**To:** Janet Hansen/SMRT – Brent Poulin/Cainbro  
**From:** Mike Nugent/Manager of Inspection Services  
**Date:** 08/18/2003  
**Re:** 65 India St. (020 E020) Vertical Expansion

## Final questions

G8 STAIR SECTION

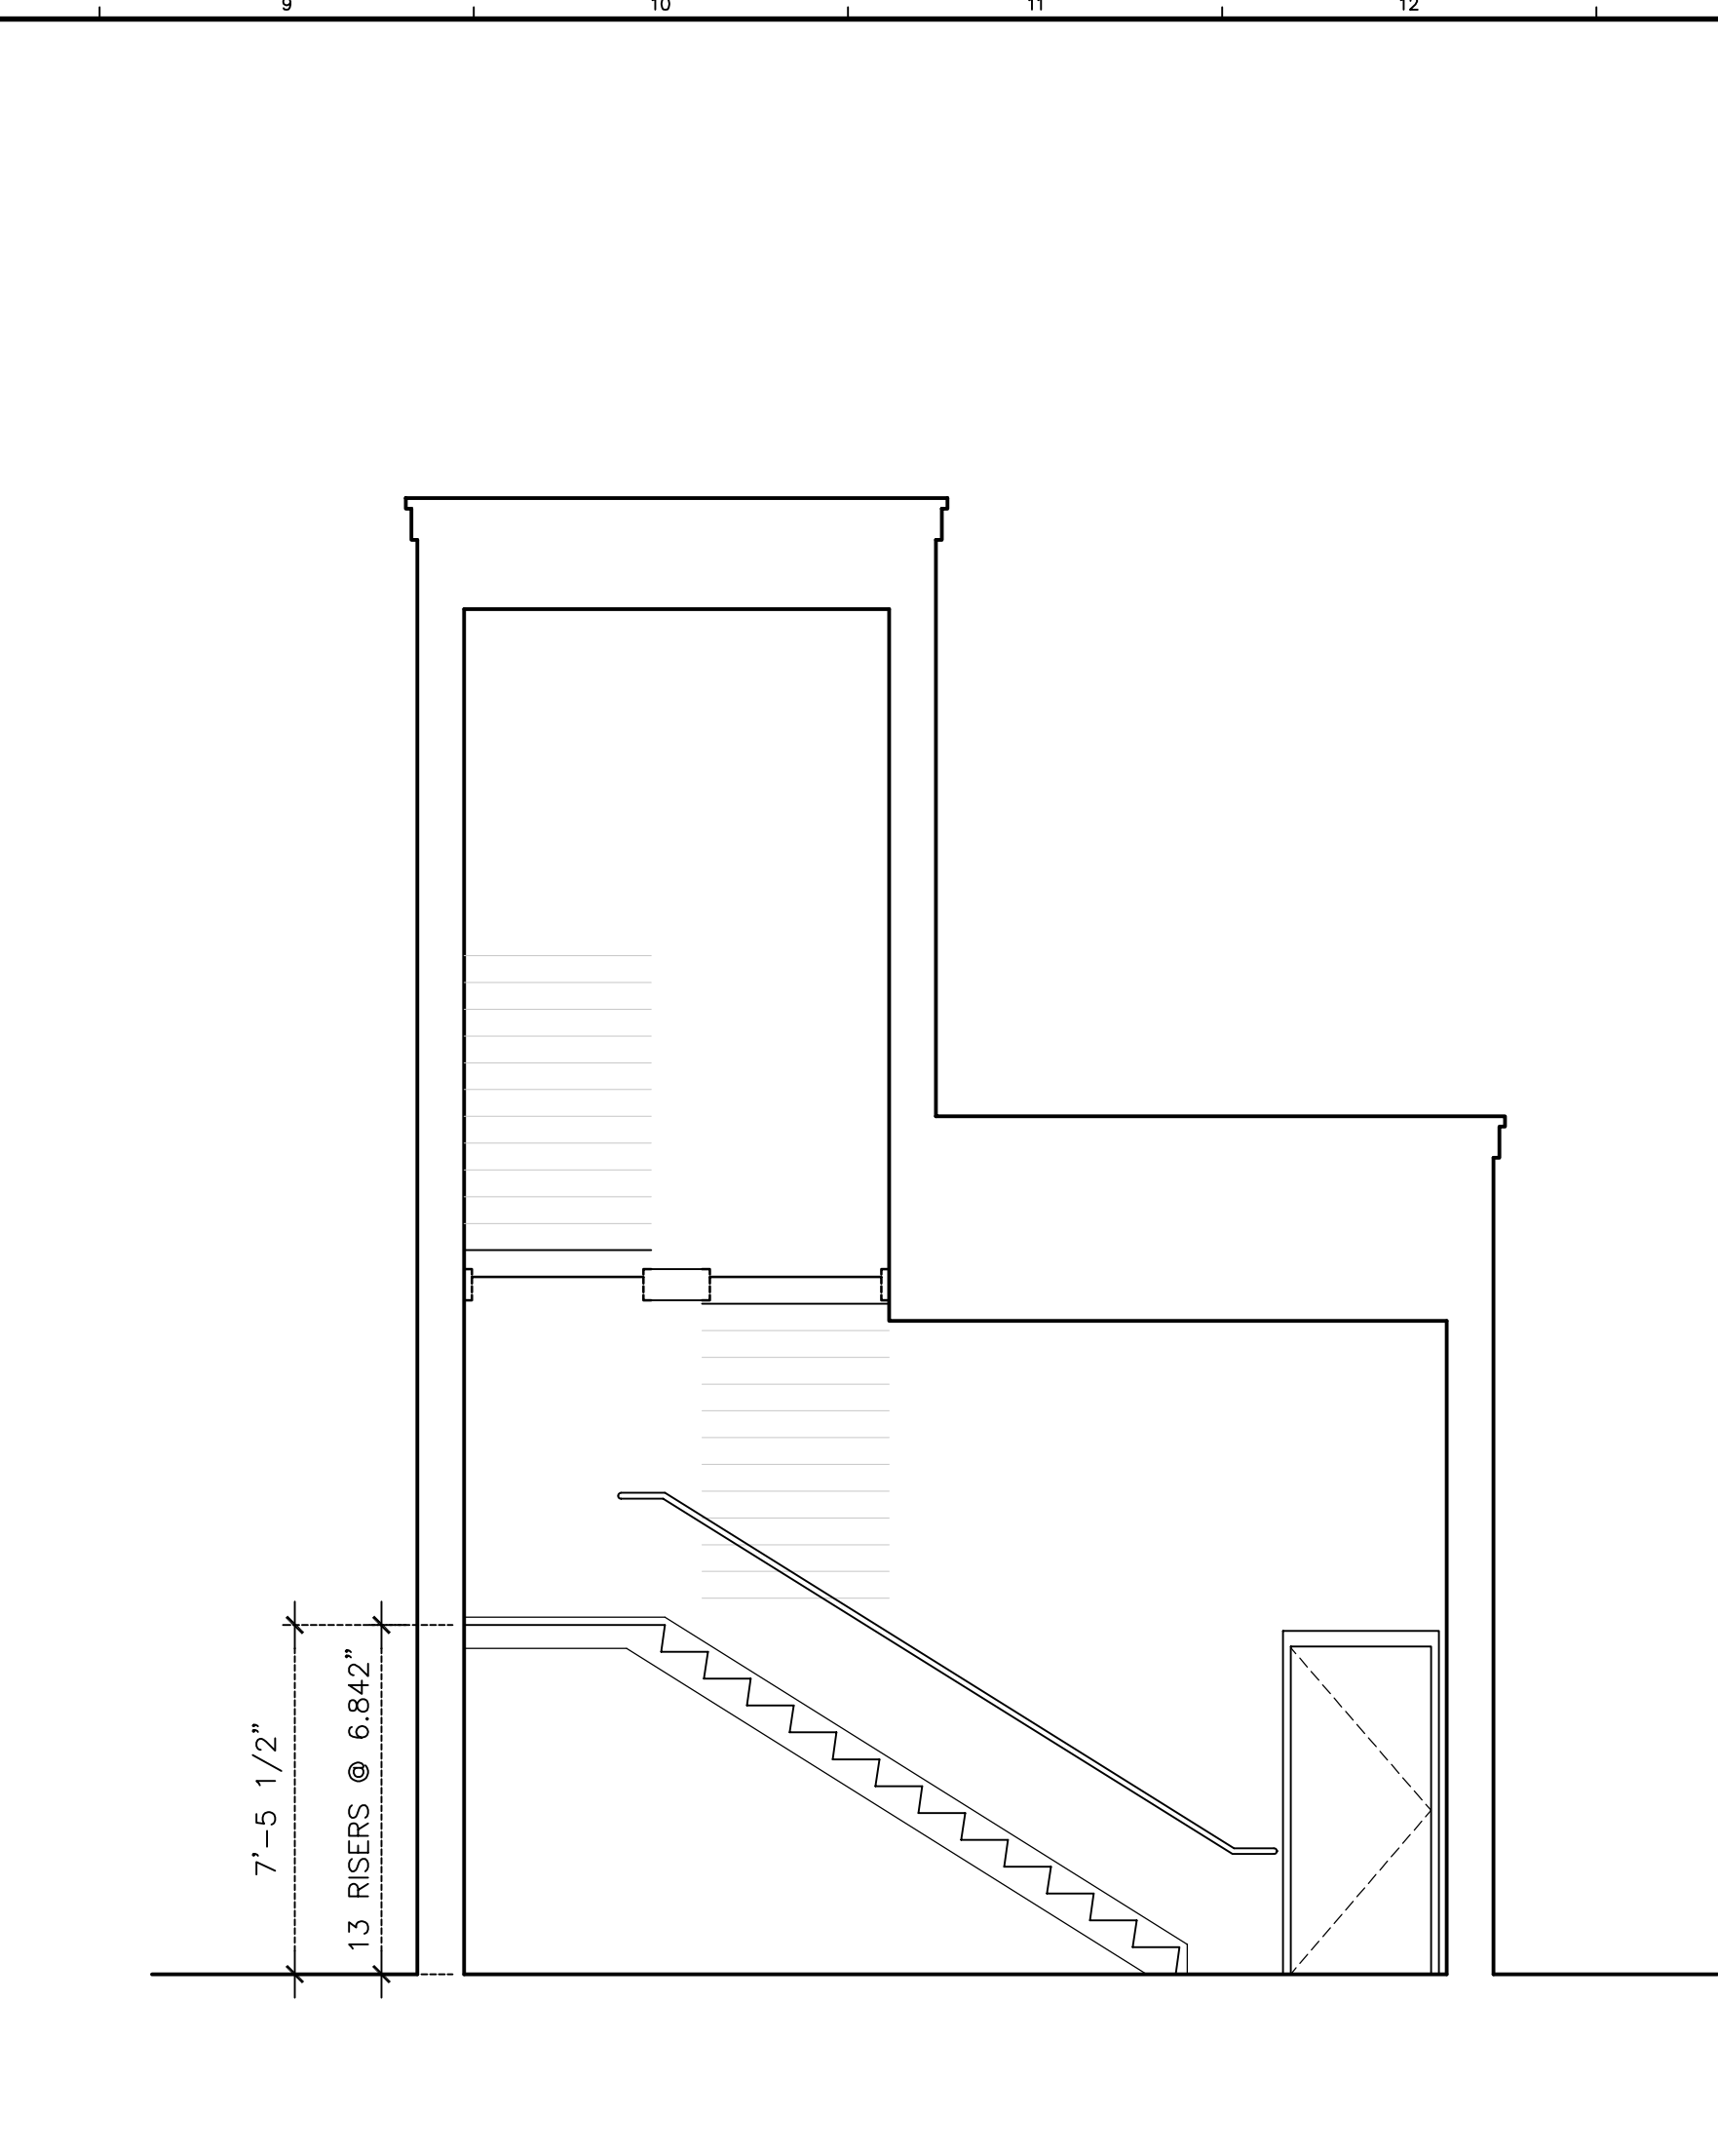
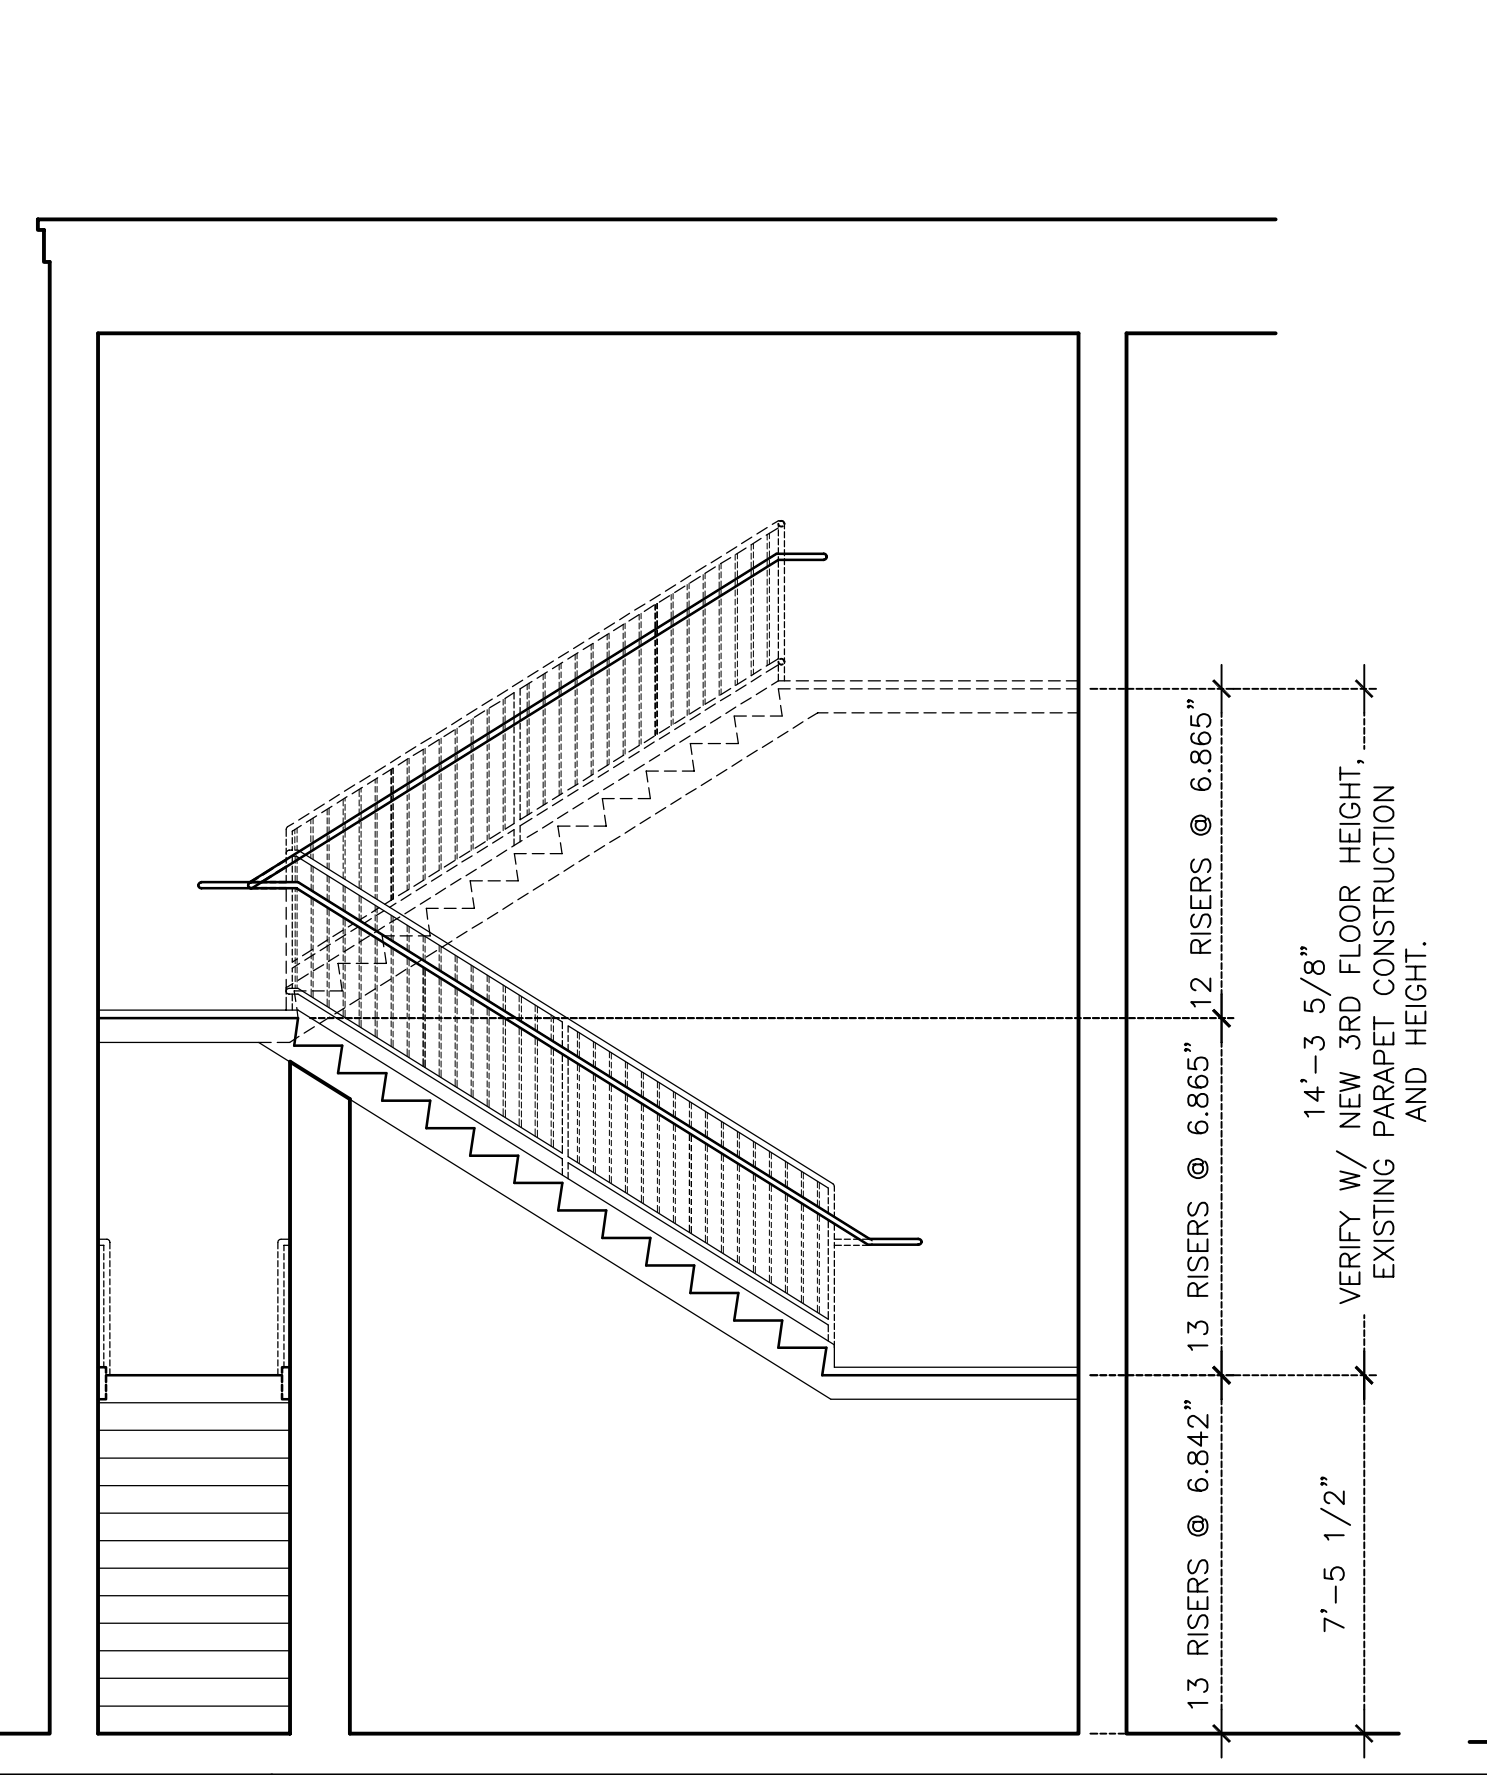
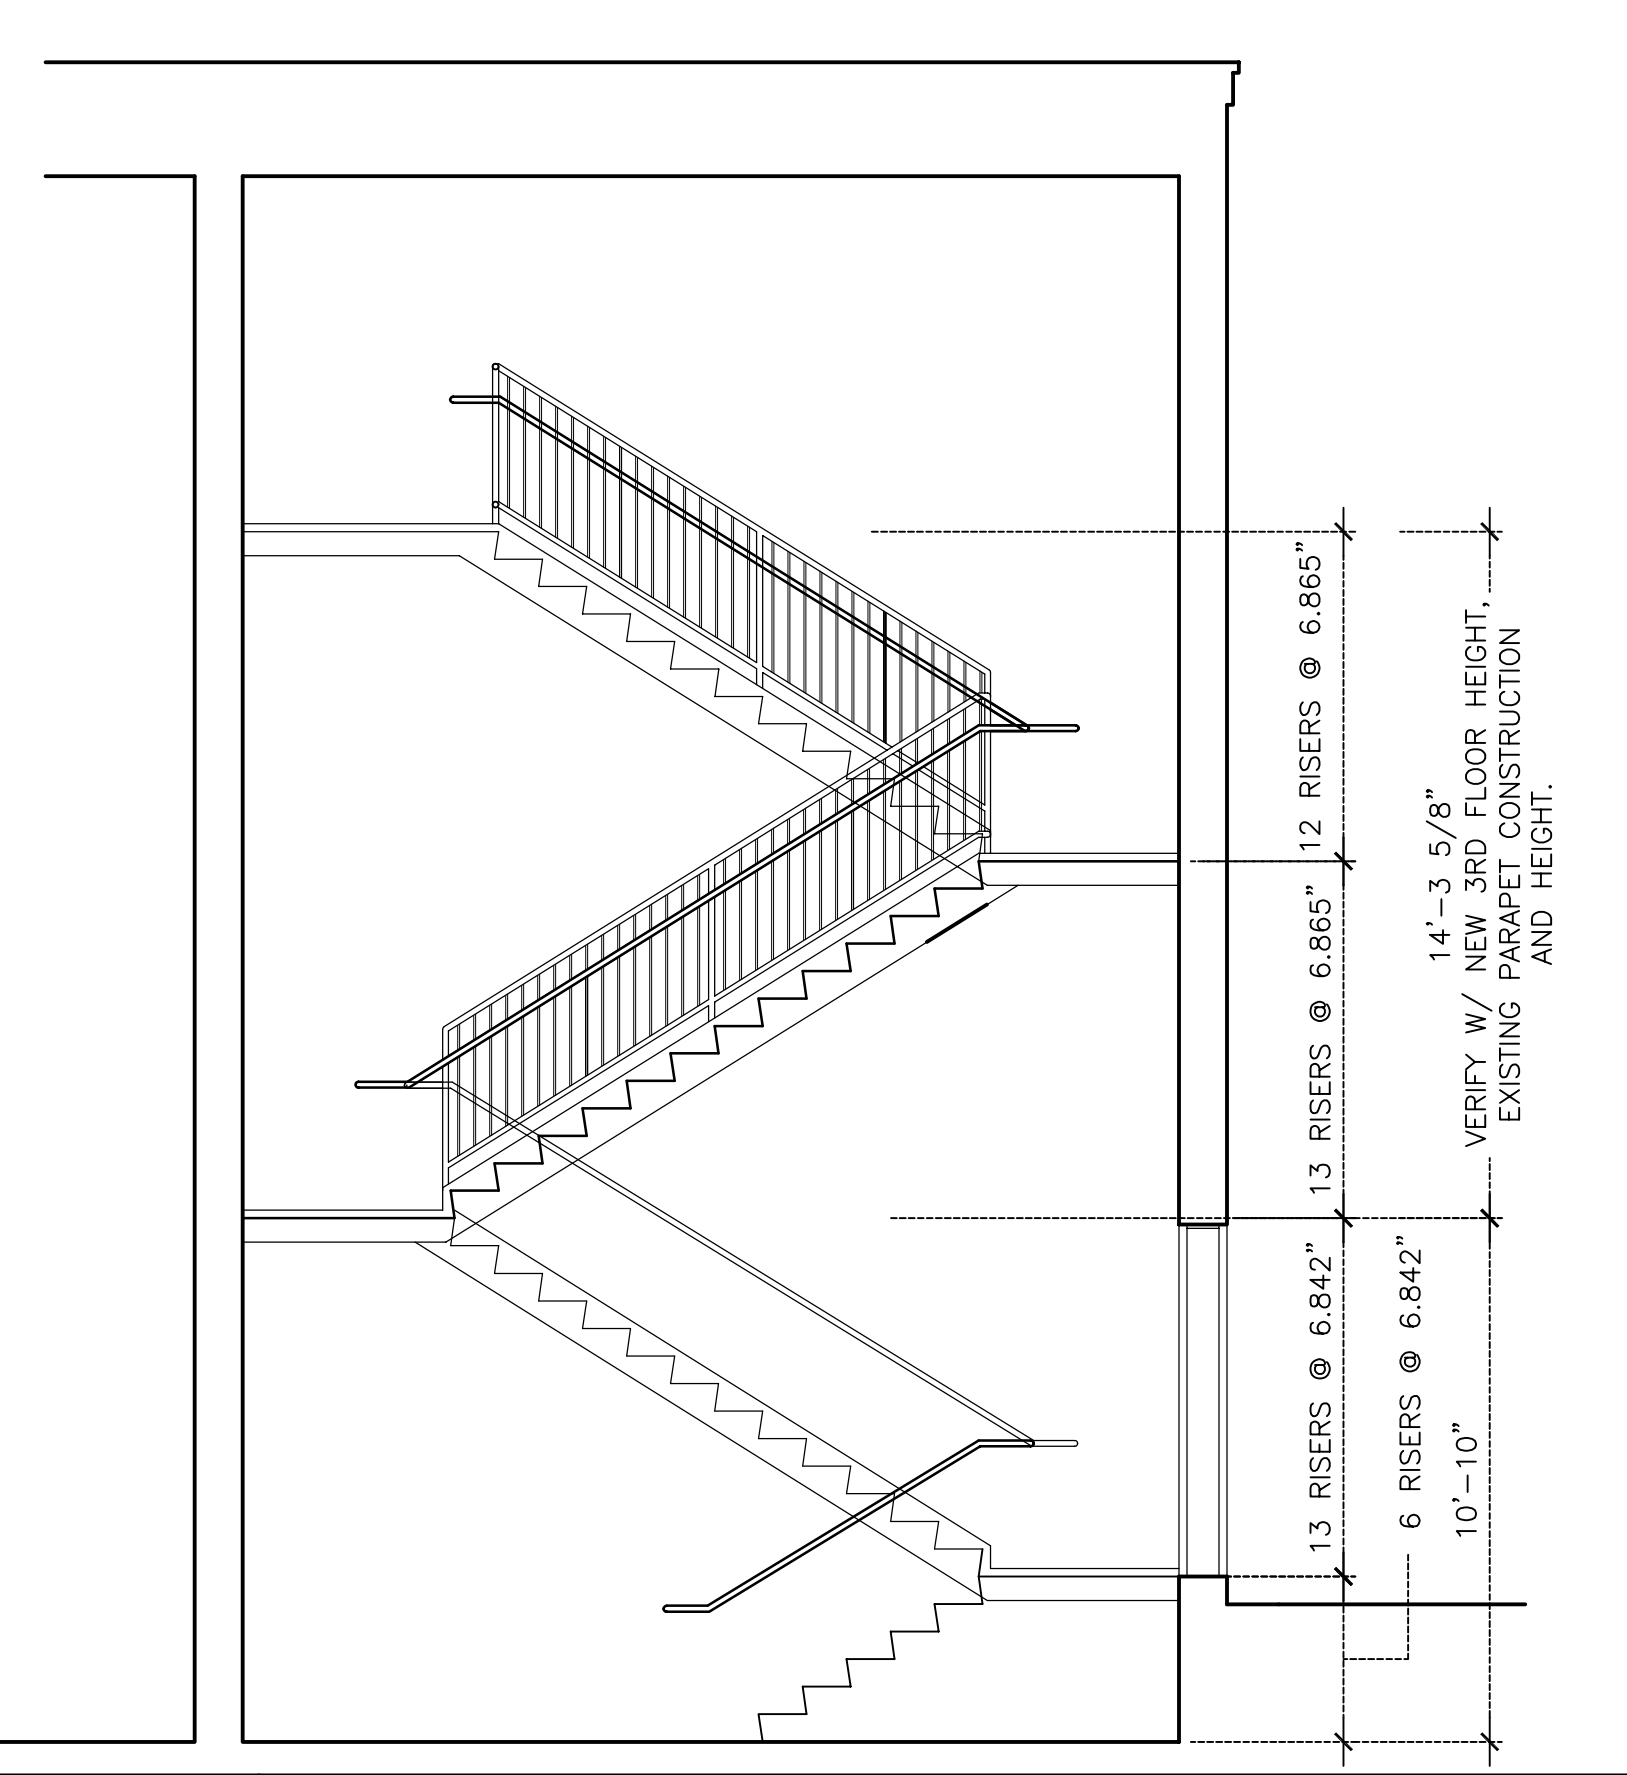
- 1) It appears that the new rear walls and stair towers on the East elevation are within 5 feet of the property lines. Your proposal shows a type “2” wall which has a 1 hour rating, this must be 2 hr.
- 2) What is the rating of the roof system?
- 3) I see references to your tread dimensions but not the risers. Where can I find that?
- 4) The letter from the engineer certifying the ability of the old structure to hold the new one? Can't seem to locate that in the “pile”
